From: FRS Water and Access REDACTED
Sent: 15 January 2025 12:57
To: Planning.Responses <Planning.Responses@arun.gov.uk>
Subject: Large Development Hydrant Condition - AL/143/24/RES Land adjacent to Woodgate Nurseries
Lidsey Road Aldingbourne PO20 3SU

HYDRANT CONDITION CONSULTATION WITH PLANNING AUTHORITY

Planning Ref: AL/143/24/RES

Address: Land adjacent to Woodgate Nurseries Lidsey Road Aldingbourne
PO20 3SU

Drawing Title:			
Phase 1			
Vehicle Tracking Movement.			
Fire Appliance			
Designer's Risk Assessment Reference:			
DS_0707_15/DRA/Civils			
Specification Reference:

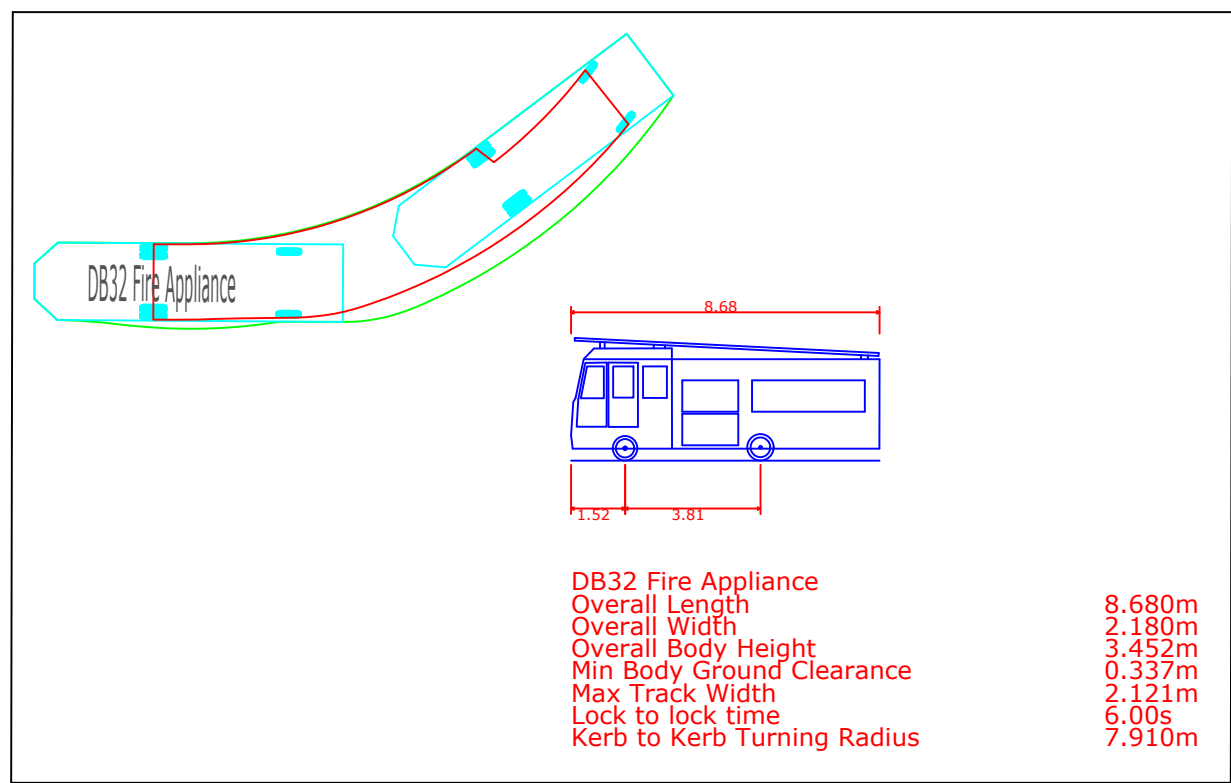
Evidence will also be required that Fire Service vehicle access meets with the requirements identified in Approved Document B Volume 1 2019 Edition: B5 Section 13, including Table 13.1 and diagram 13.1.
